Re: Willow Springs Ranch/Forest Lakes Drive Access (CDR-21-005)

Please accept this response letter to comments received September 8, 2021

Figure 2
Site Plan

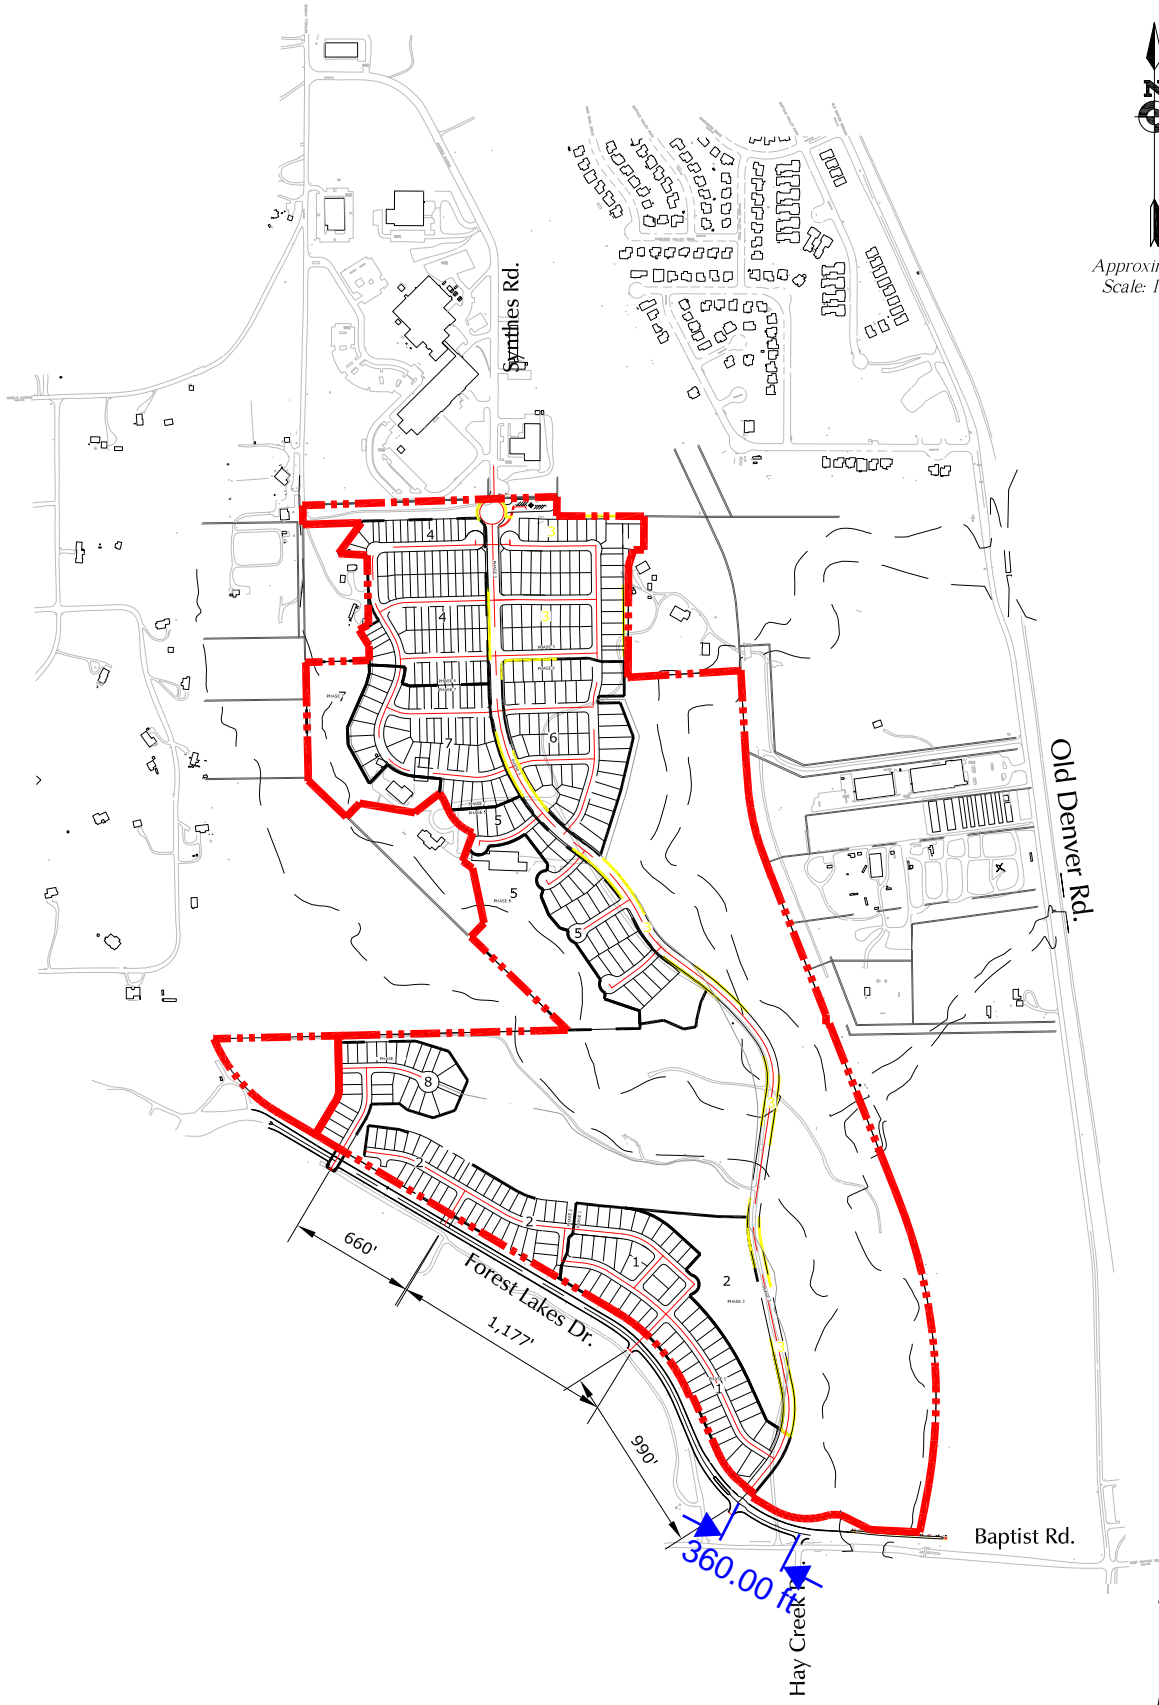
1. Per General comment #3 above, if the plan is not revised, provide a deviation request addressing intersection spacing between Hay Creek Road and proposed Willow Ranch Road on Forest Lakes Drive. Add this dimension on Figure 2 (Site Plan) and provide with the deviation request. **See deviation request redlines. Request updated and signed.**
2. Note: The westbound deceleration lane at Willow Ranch Road needs to be constructed with the access improvements. A condition **has been** placed on the access permit to require this. ***Acknowledged.***
